M3 Junction 9 Improvement Scheme

7.12.7 Statement of Common Ground with Cycle Winchester (Rev 1)

**7.12.7 STATEMENT OF COMMON GROUND WITH CYCLE
WINCHESTER**

This Statement of Common Ground has been prepared and agreed by (1) National Highways Company Limited and (2) Cycle Winchester

**PROJECT STAGE**  
 PCF STAGE 3

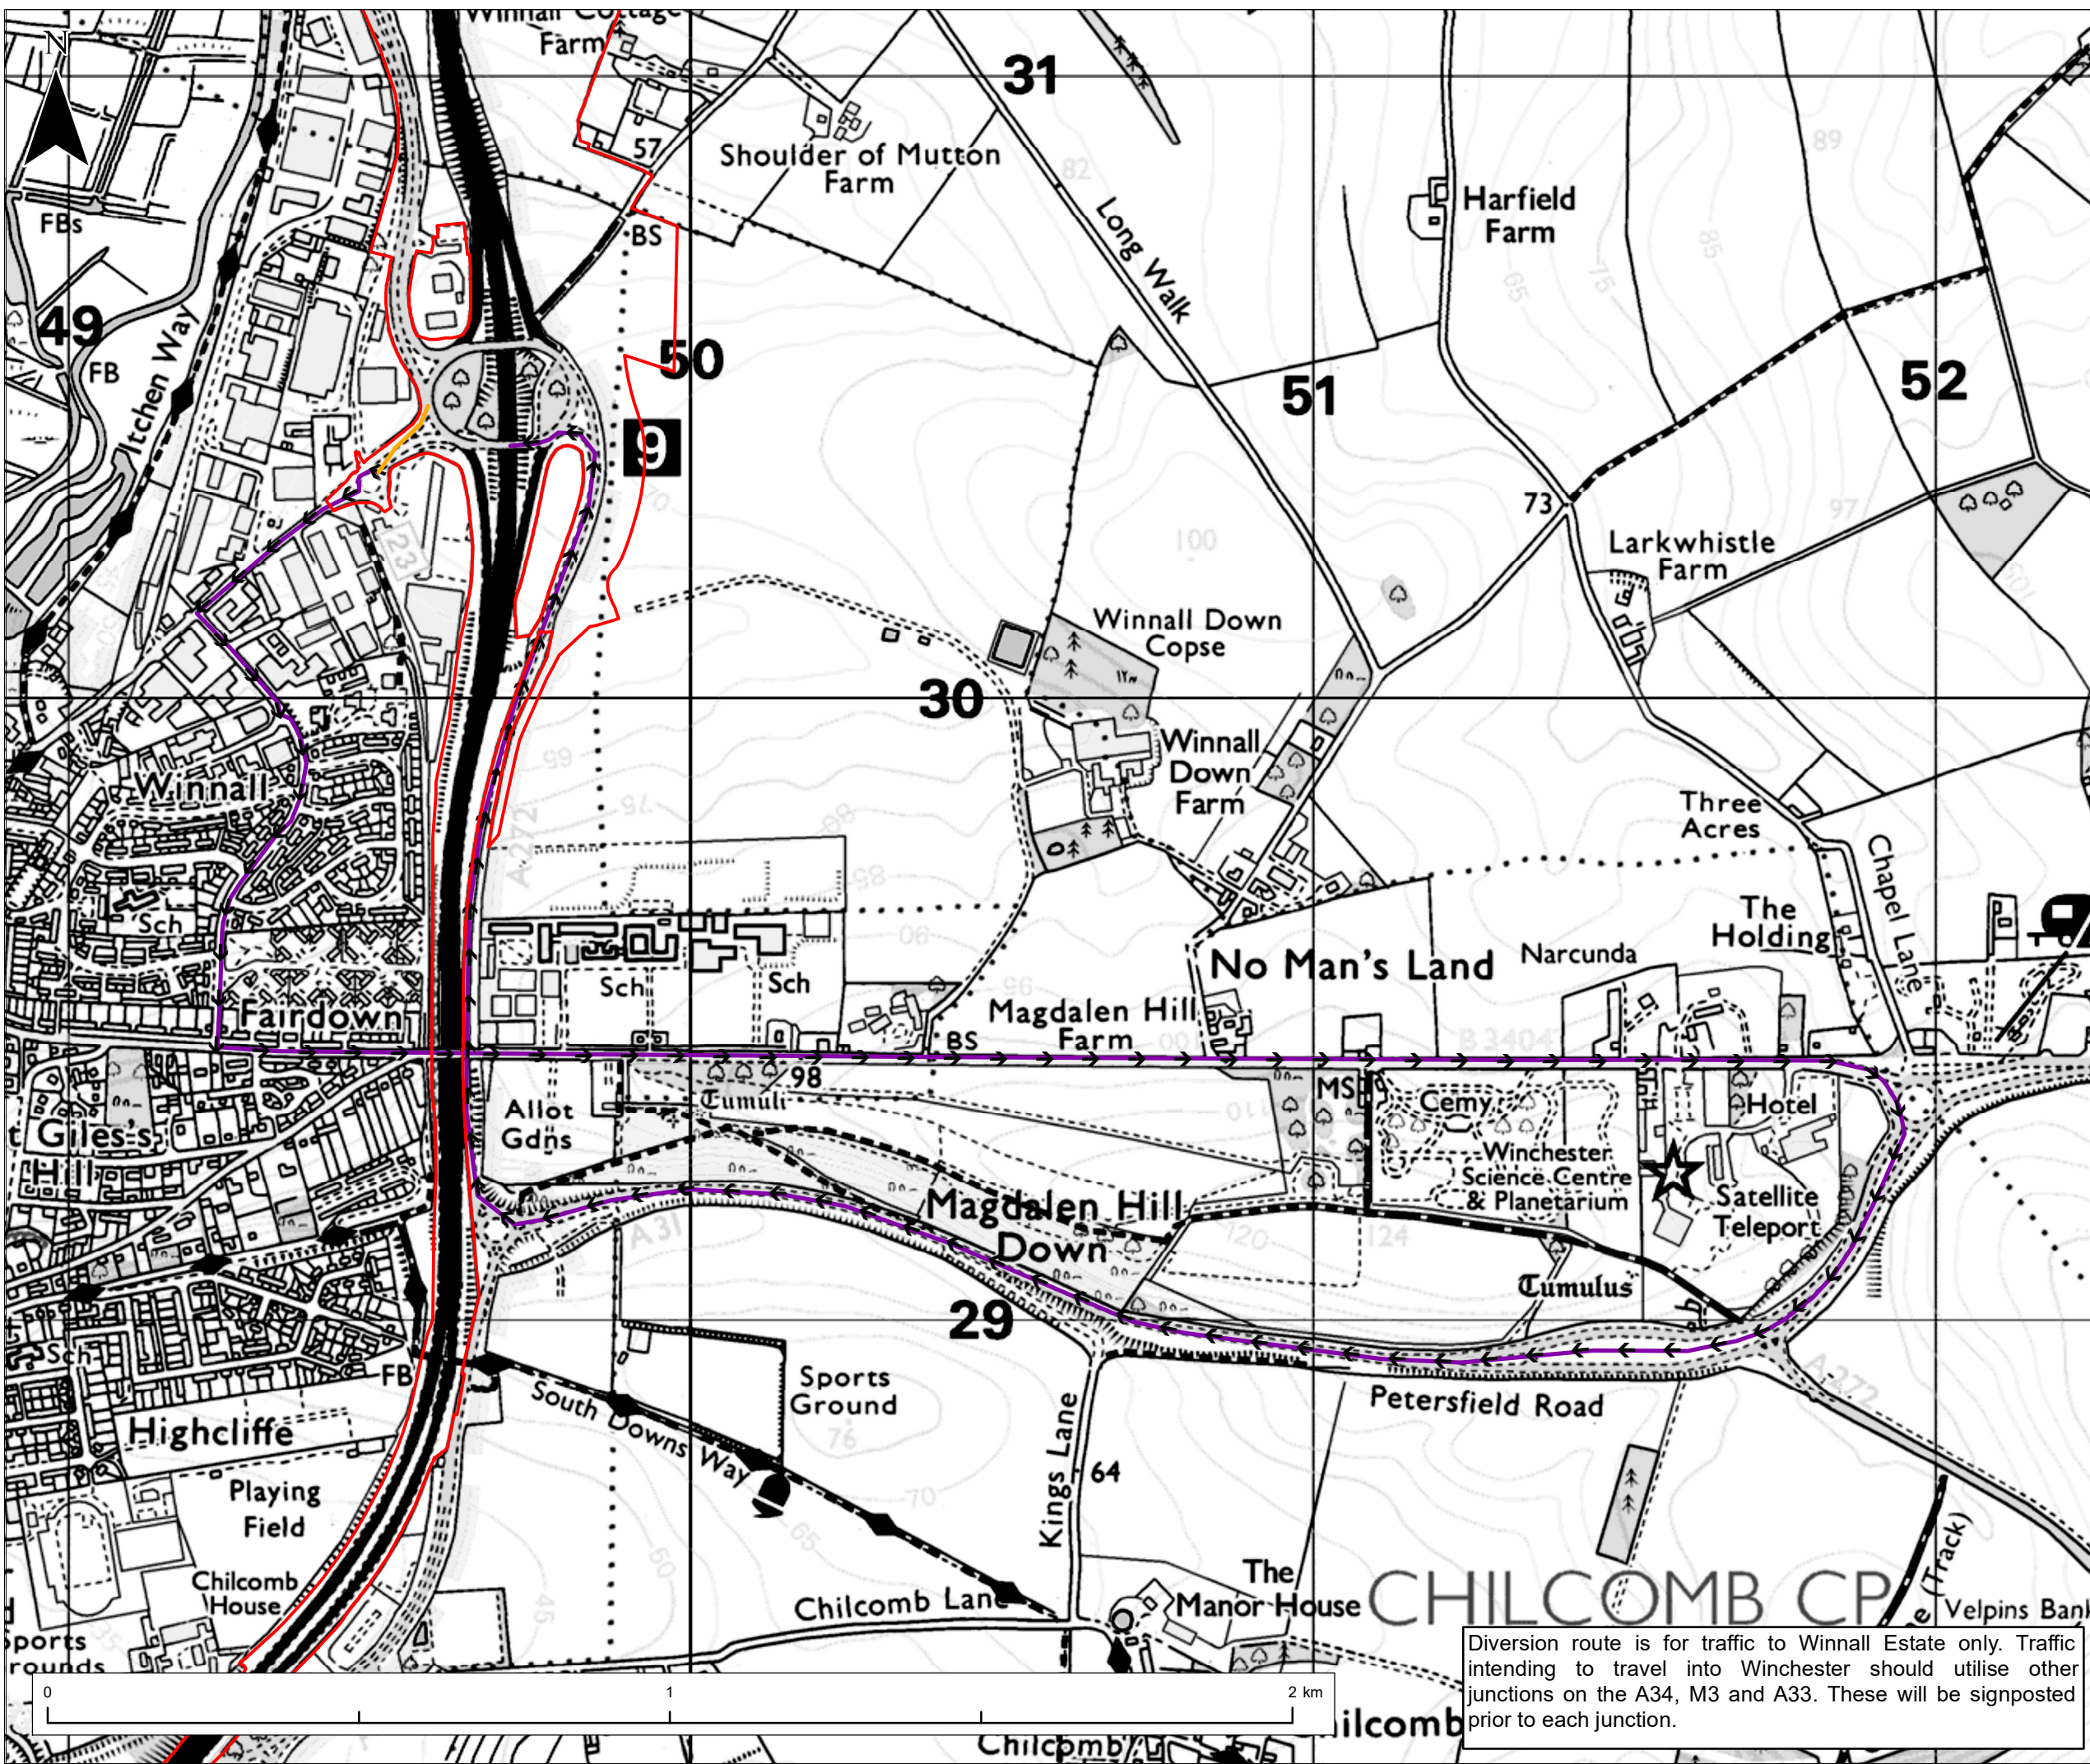
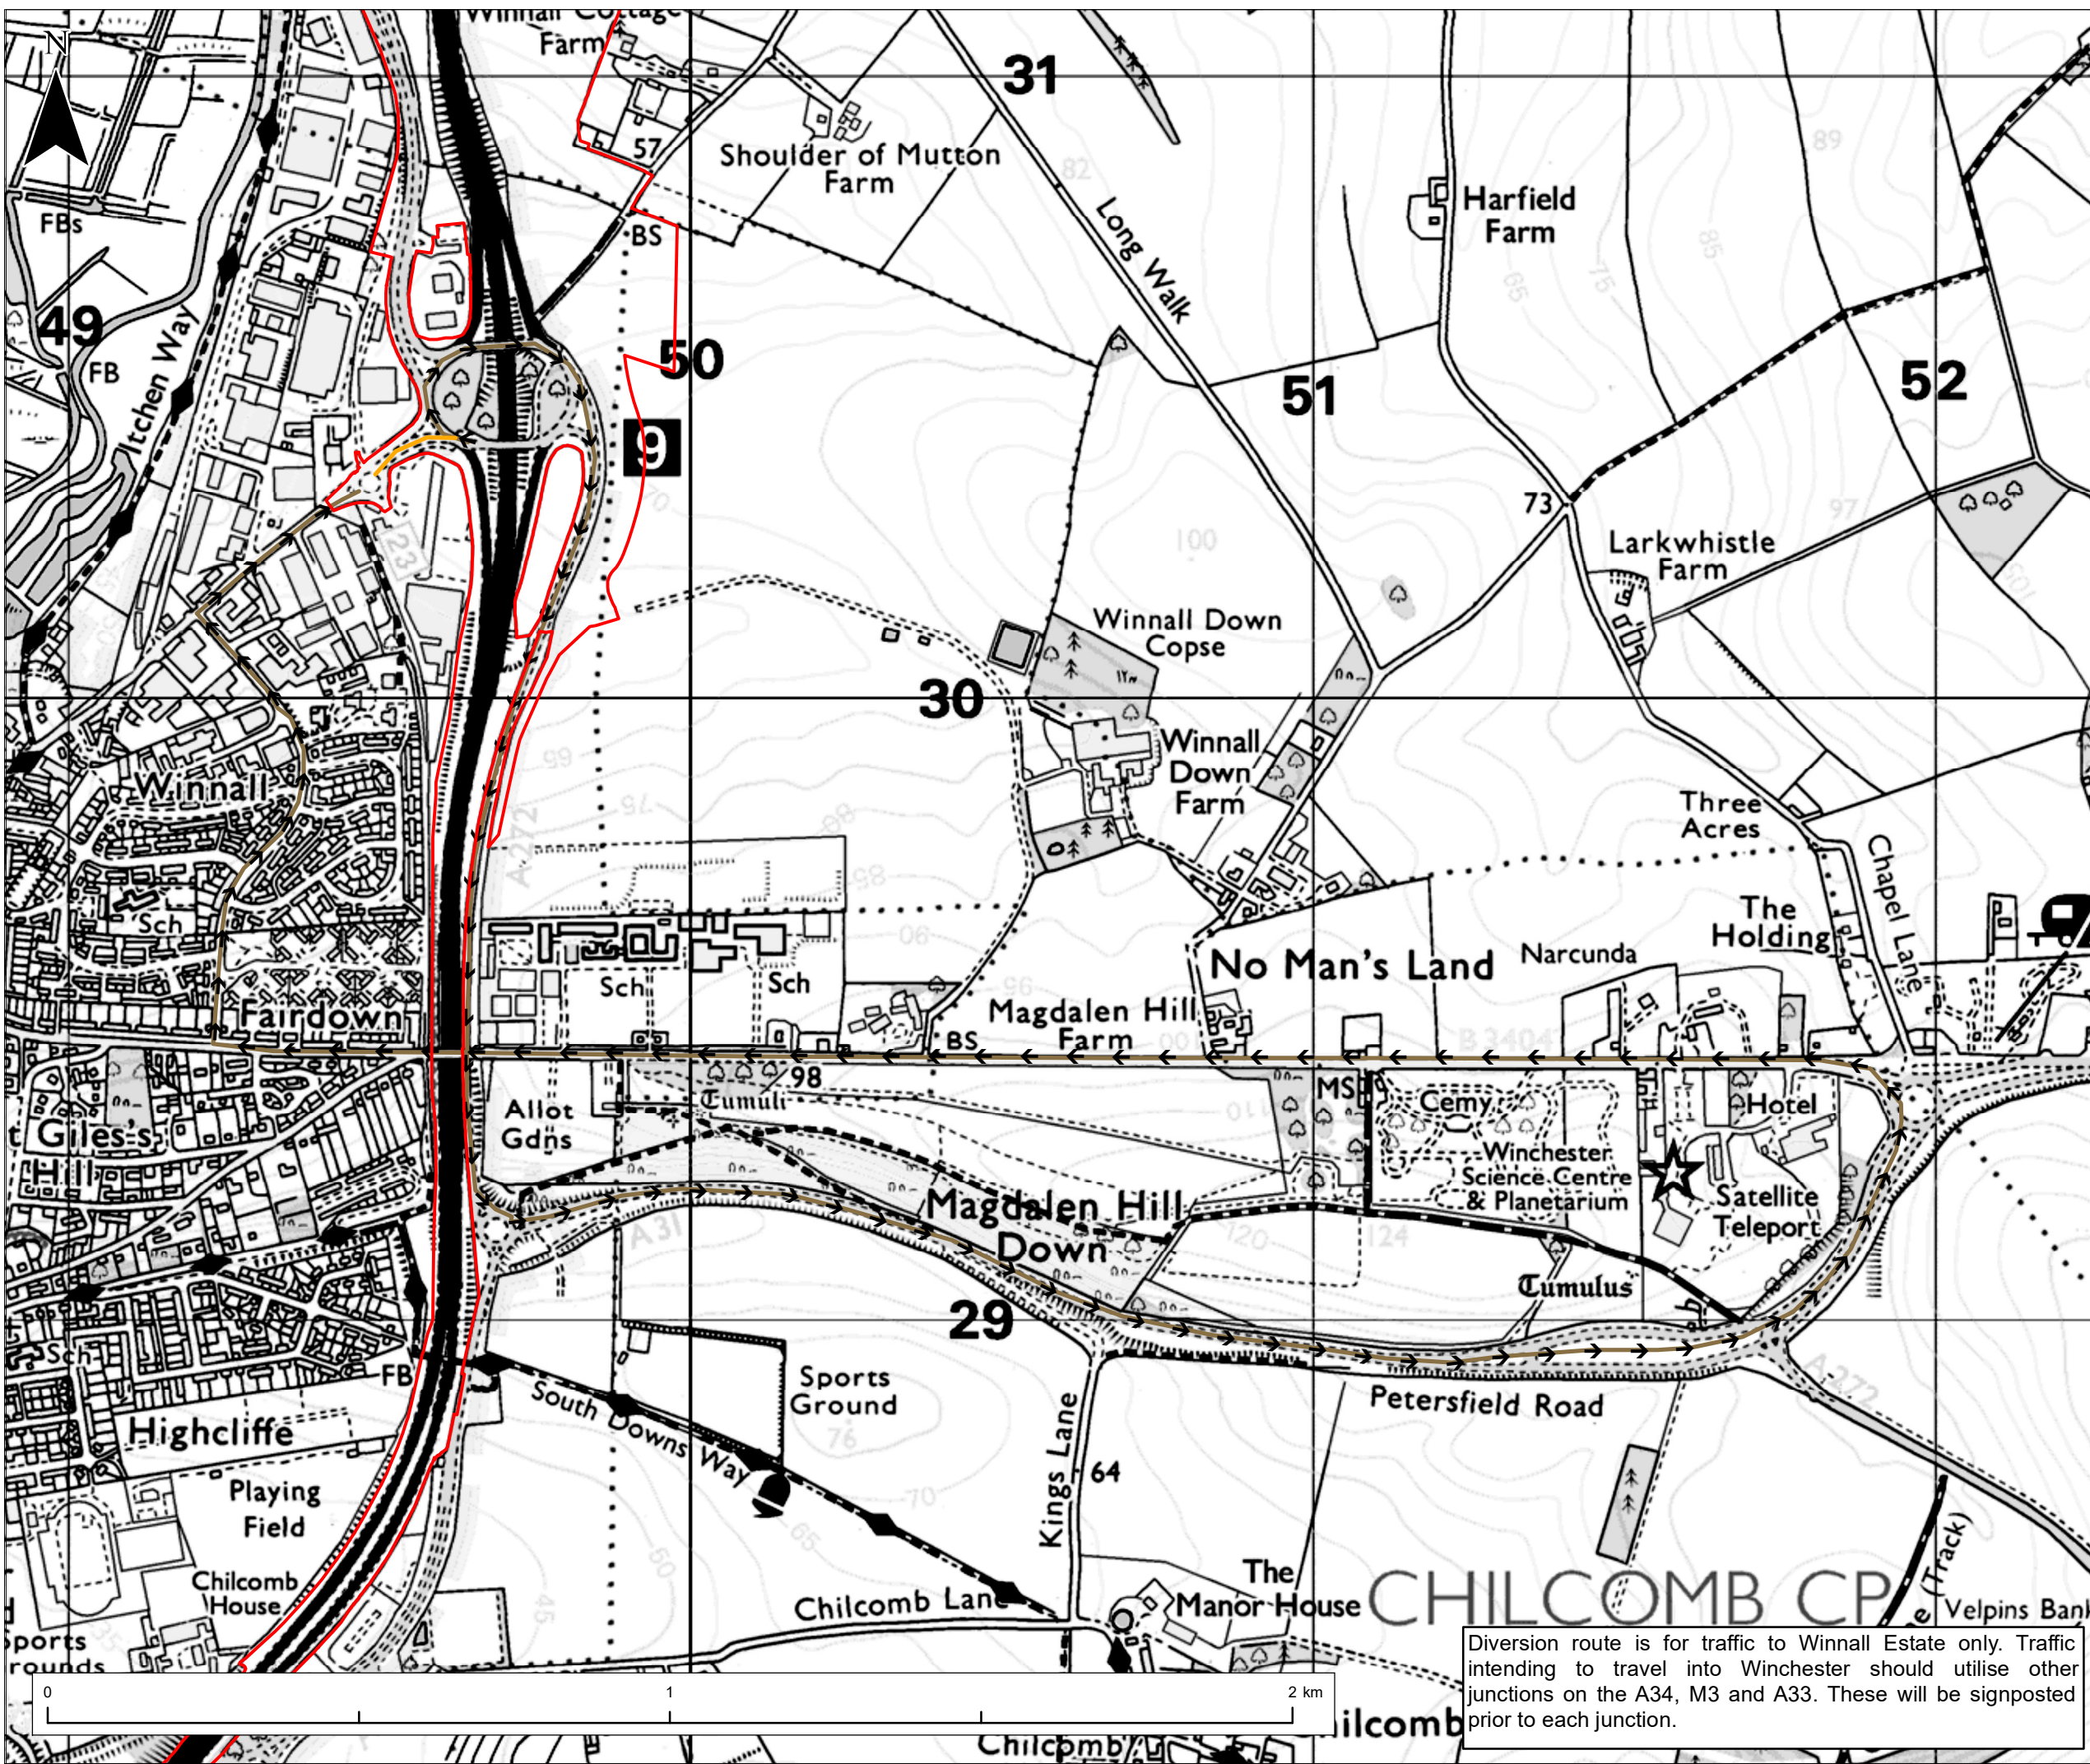
5.2	<p>Diversion routes Impact of traffic diversion on cyclists</p>	<p>Outline Traffic Management Plan (7.8, Rev 1), Figure 2.5 of Chapter 2 (The Scheme and its</p>	<p>Cycle Winchester has the impression that the project team has not yet considered the impact that traffic diversions during construction will have on cyclists. Examples of areas where the diverted traffic might have an impact on cycling</p>	<p>Diversion routes via the B3047, the B3420 Andover Road and road east of the junction (A31) will be implemented at various stages of the Scheme. The works are planned to be undertaken during overnight off-peak closures</p>	<p>Not agreed</p>	<p>8 November 2023</p>

Reference	Issue	Document References (if relevant)	Cycle Winchester's Position	National Highways' Position	Status	Date
		<p>Surroundings – Figures (Part 3 of 4) of the ES (6.2, APP-063)</p>	<p>include many of the major routes in and out of Winchester, as a Junction 9 closure or complete M3 closure would force more traffic onto these roads. Some examples:</p> <ul style="list-style-type: none"> ▪ B3047 Worthy Road/Martyr Worthy Road ▪ B3335 St Cross Rd and Twyford Road ▪ B3420 Andover Road ▪ B3330 Bar End Road ▪ Minor roads, especially in the upper Itchen valley east of the junction <p>In addition, the location of the site offices and parking immediately to the east of the junction suggests that the likely travel-to-work route of staff working on the project would clash with the proposed cycling diversion routes as well as impacting walkers, cyclists and horse riders on the section of NCN23 near Easton village. (See 6.2 Environmental Statement Chapter 2 The Scheme and its Surroundings - Figures Part 1 of 4).</p> <p>Again, we would like to see a clear consultation process that will ensure that consultation happens, that the effects on non-motorised road users are accounted for, and appropriate measures are taken.</p>	<p>(when there is less traffic on the network) and several extended weekend closures.</p> <p>The B3335 St Cross and Twyford Road and B3330 Bar End Road have been referenced as secondary diversion routes and should only be used by non-motorway traffic, or for those accessing the residential area at Bar-End.</p> <p>There are mitigation measures for rat-running and this will be monitored throughout construction of the Scheme.</p> <p>National Highways commit to producing a PRoW Management Plan during detailed design. National Highways will have regard to Cycle Winchester's views during the development of the PRoW Management Plan during detailed design. This will include controls to manage the crossing of the haulage route and NCN Route 23 and on Long Walk.</p>
